In 2019, planning officer Neil Bearcroft made a comprehensive and considered assessment of the garden site at 39 Far End Lane. The subsequent 2019 OPP was supported by local residents.

So in 2022, the application was 'resubmitted' with the same layout and is now considered by a third planning officer, Katie Chew.

North Elevation - 1:100

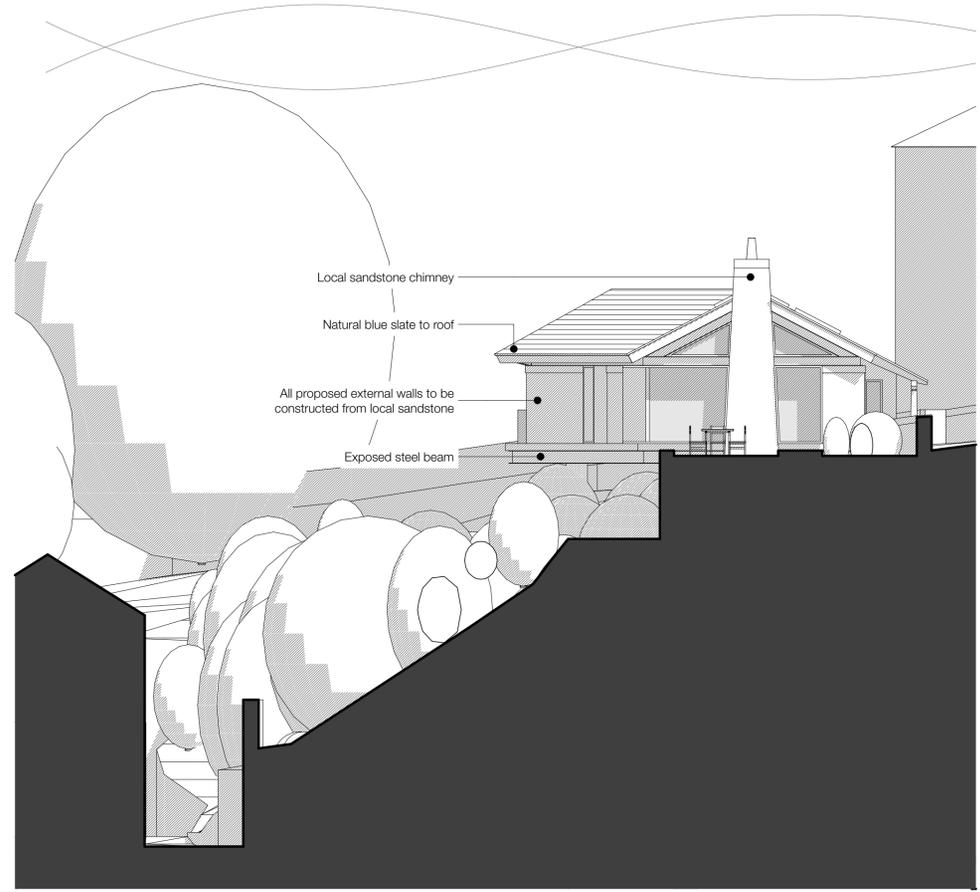
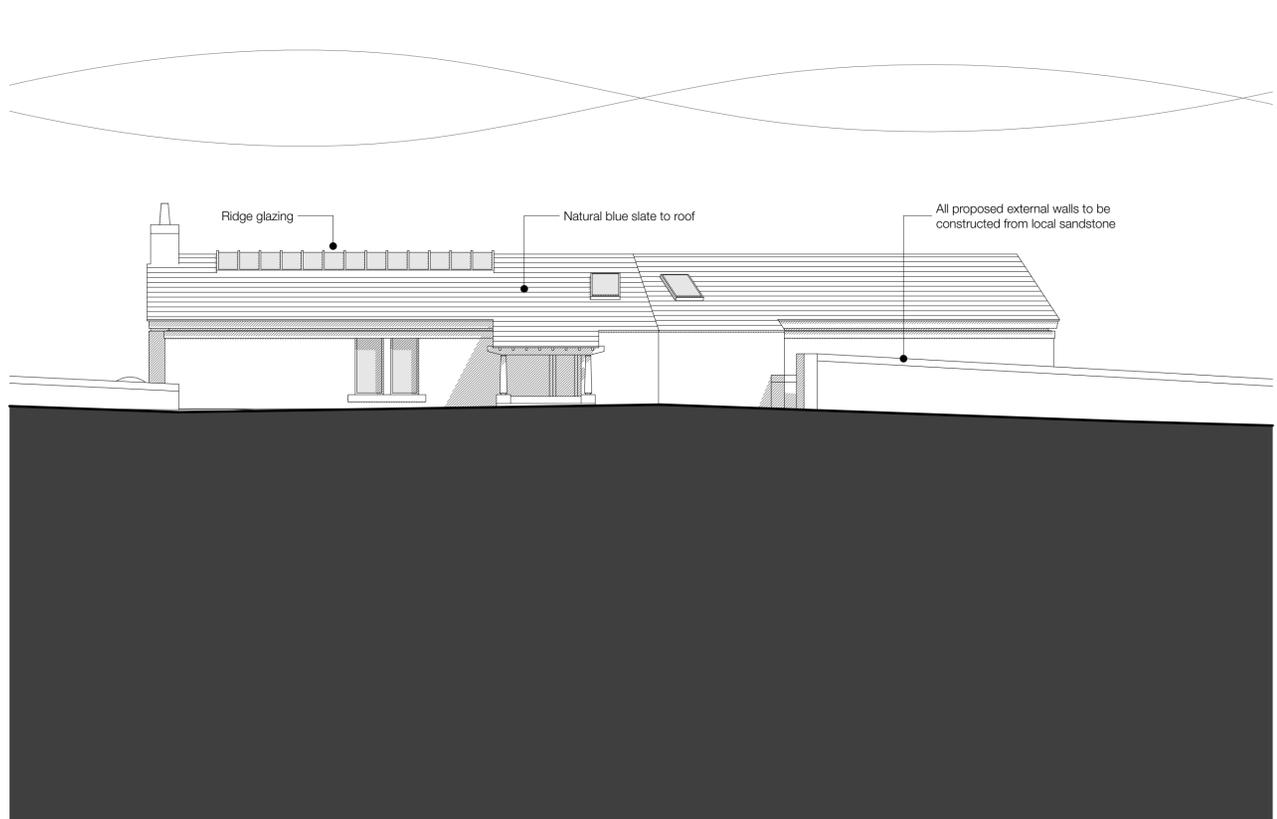
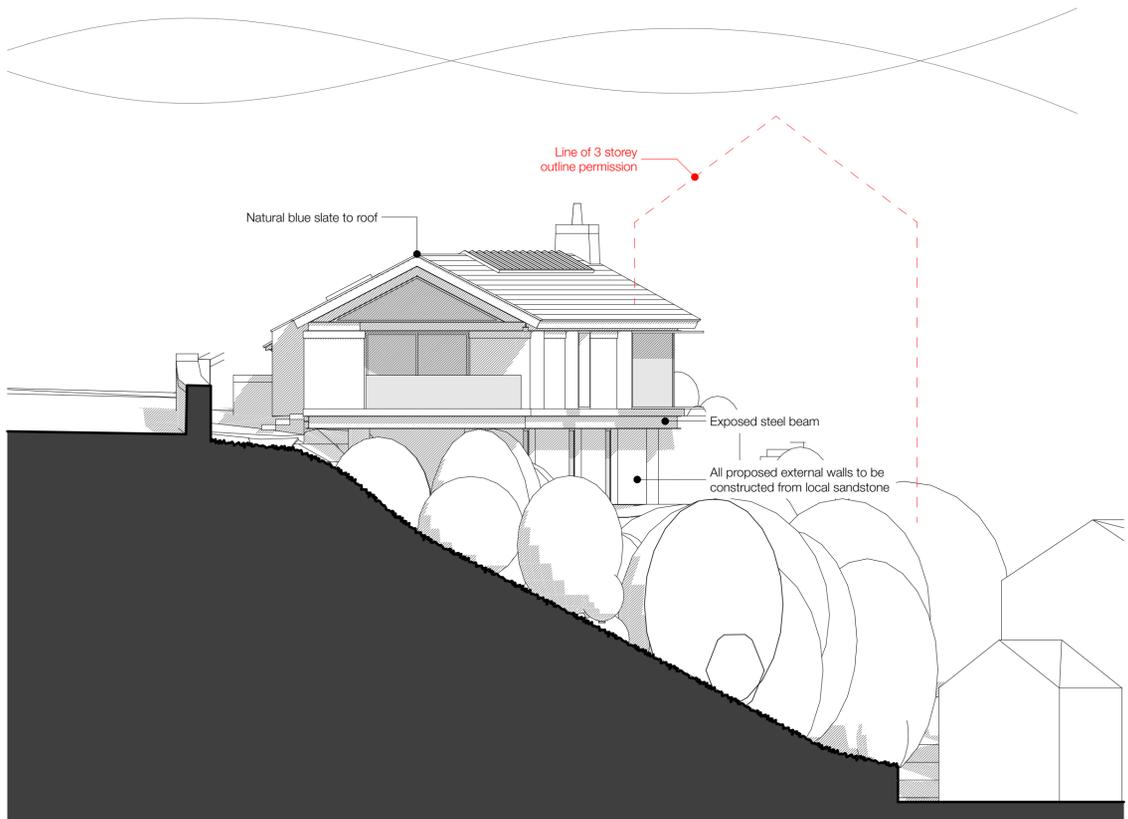
It is therefore of great concern that the proposed parking structure is not shown on the elevation plans and Highways Structures have not been reconsulted – why? - considering they previously asked for a '2m easement strip' when development was originally proposed in this very same area.

Despite objections to the Planning Officer, the applicants elevation plan is still incomplete. You cannot reasonably demonstrate the impact of the development upon no18 unless no18 is shown on the view from Woodhead Road. Sitting practically on top of no18, the proposed dwelling clearly dominates and overshadows our property. **This is clearly why no18 is not shown on the applicant's plan.**

Proposed Ground Floor Plan - 1:100

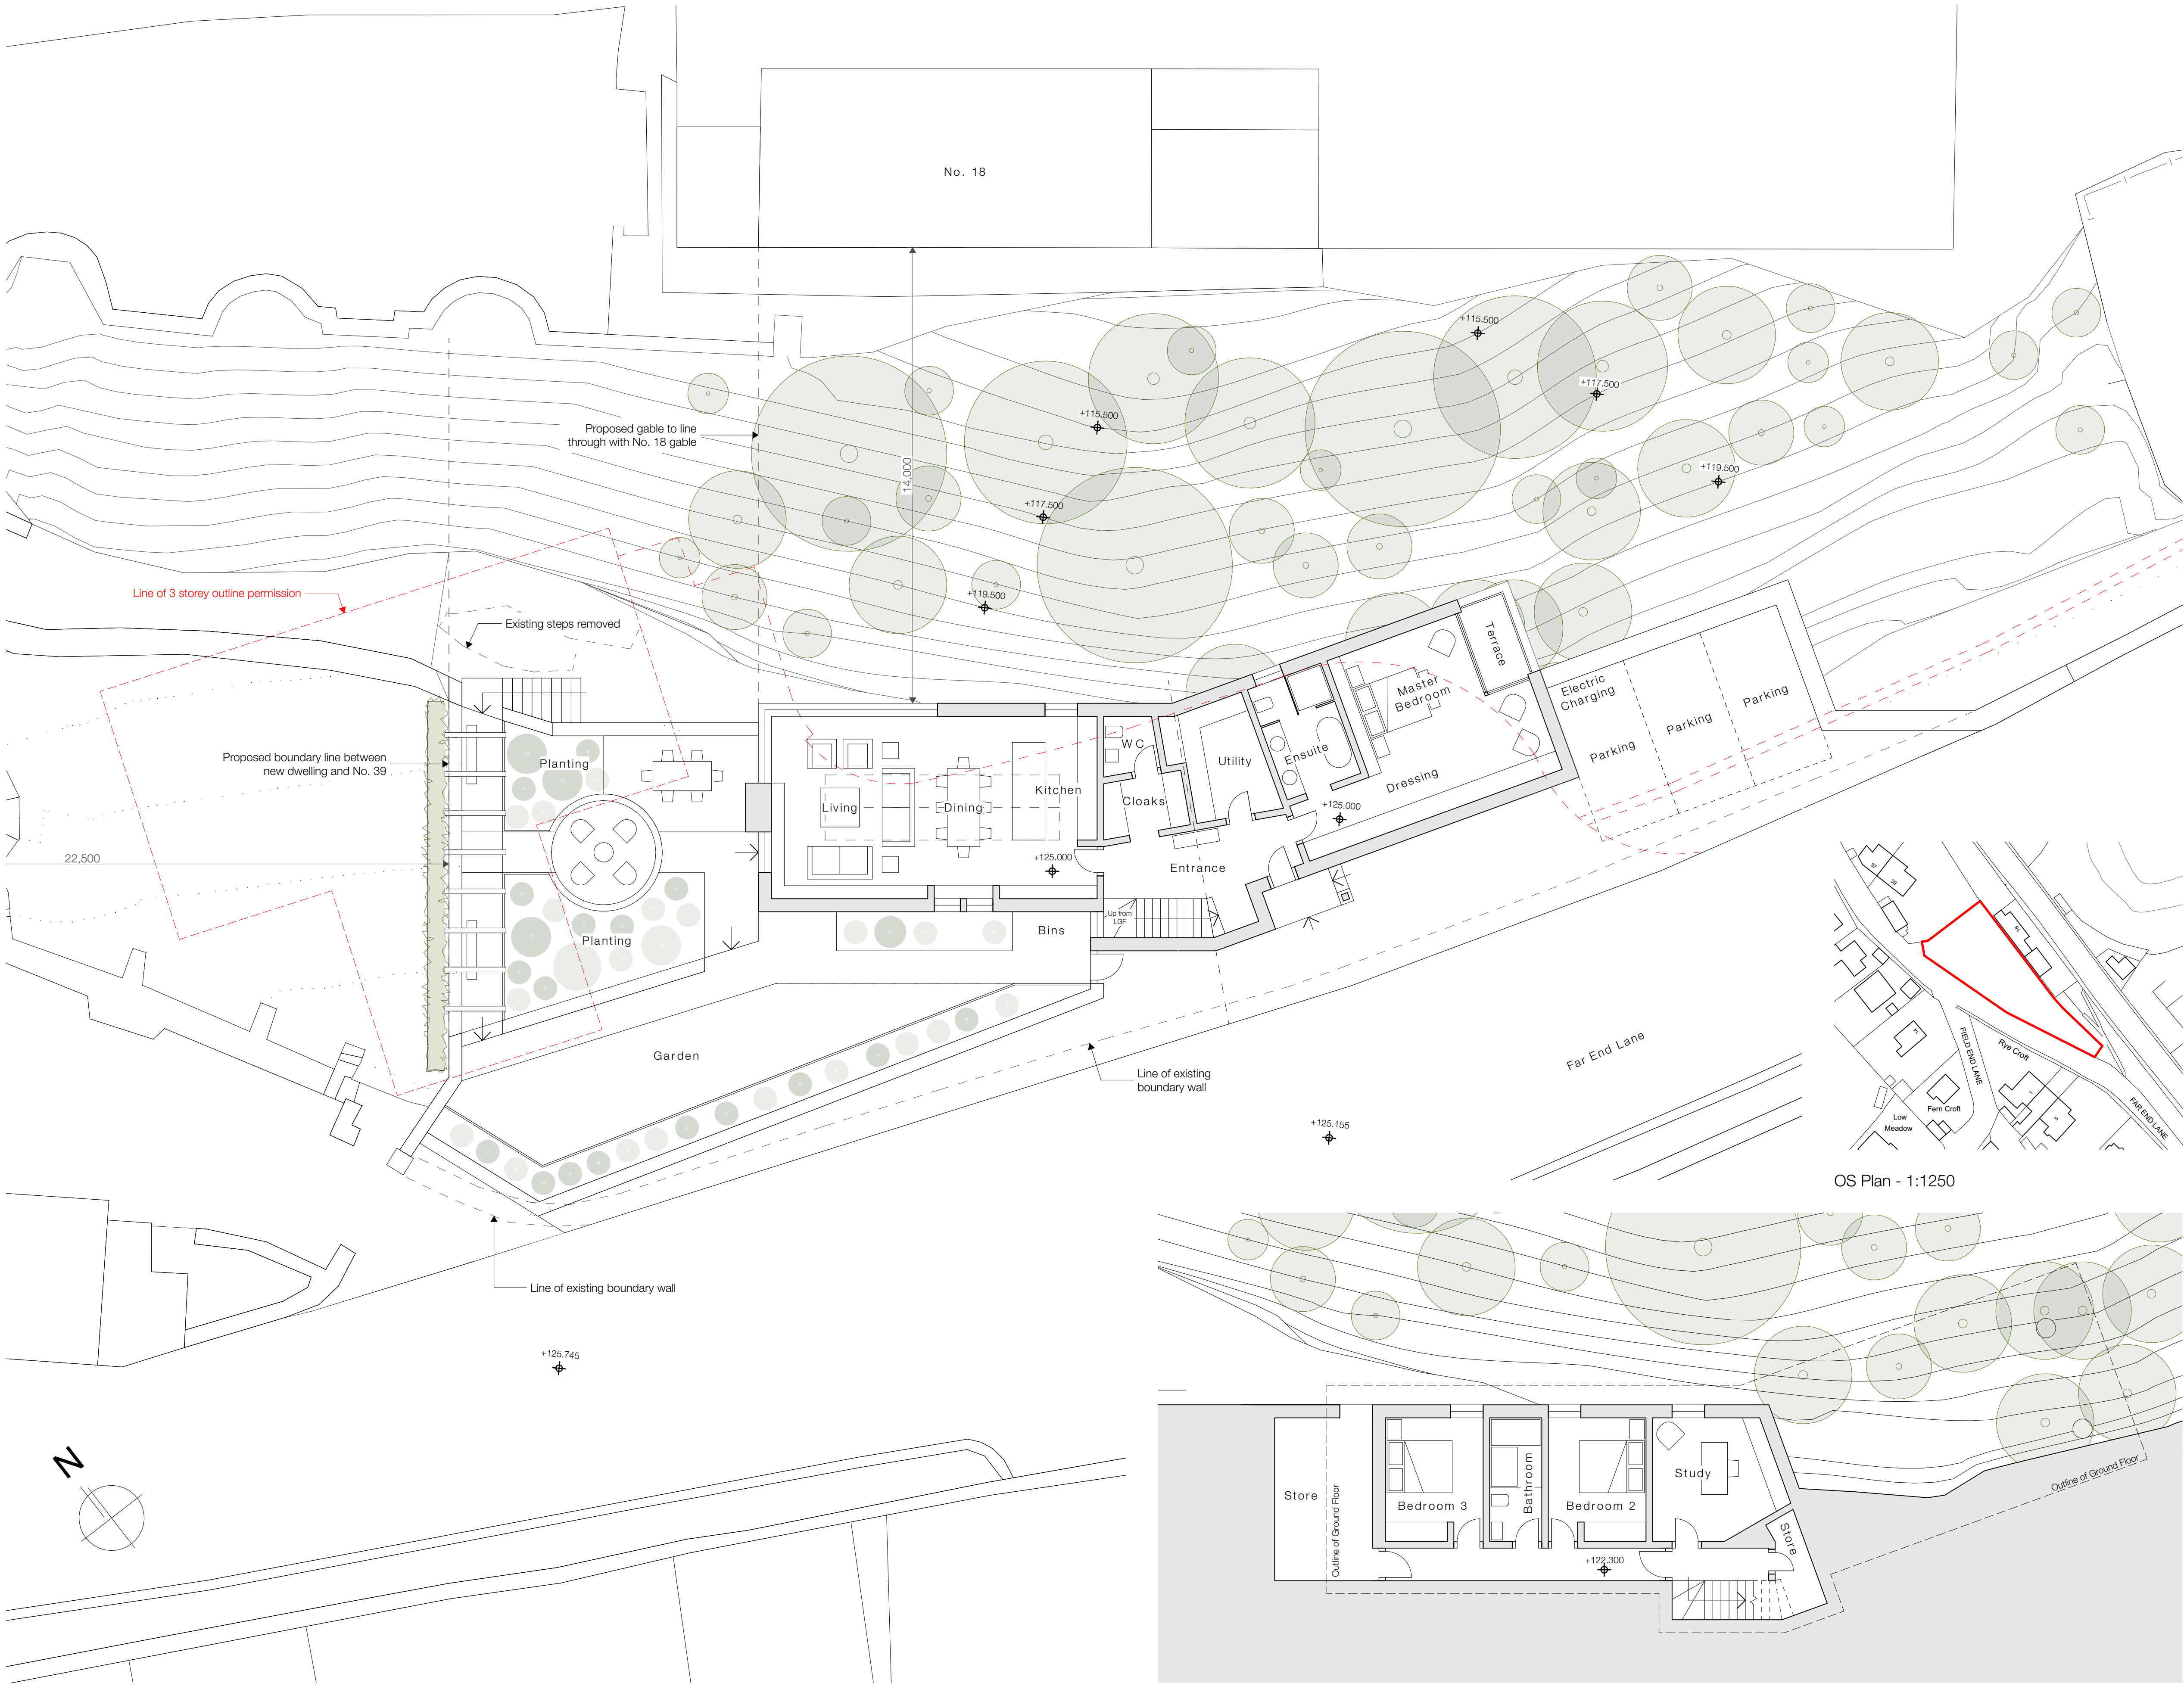
The proposed dwelling and its off road parking arrangement – undoubtedly the worse 'access' design proposed at the site - is on the steepest part of the slope. The stability of this slope is unknown. There is no footway and the ground falls away immediately after the boundary wall at the carriageway edge.

The boundaries with no 18 are incorrectly shown on the application. I have provided evidence to Katie which is also on public record. However, this is still not shown on plans **giving a misleading relationship between our property and the development.**

The Highways Officer states specifically that sightlines can be achieved 'from the central parking space'. What this means in practice is the parking area has sightlines when only one of the parking spaces is used!

In practice drivers are unlikely to want to manoeuvre within the carriageway and vehicles will instead park on Far End Lane. This arrangement is not practicable for delivery drivers or for construction traffic which will also park on Far End Lane.

It is certainly not what would be considered suitable or what would be expected to be provided for this executive, detached property. It does not provide secure parking and with the absence of a footway is akin to parking at roadside. It is undoubtedly the worse 'access' design proposed at this site.
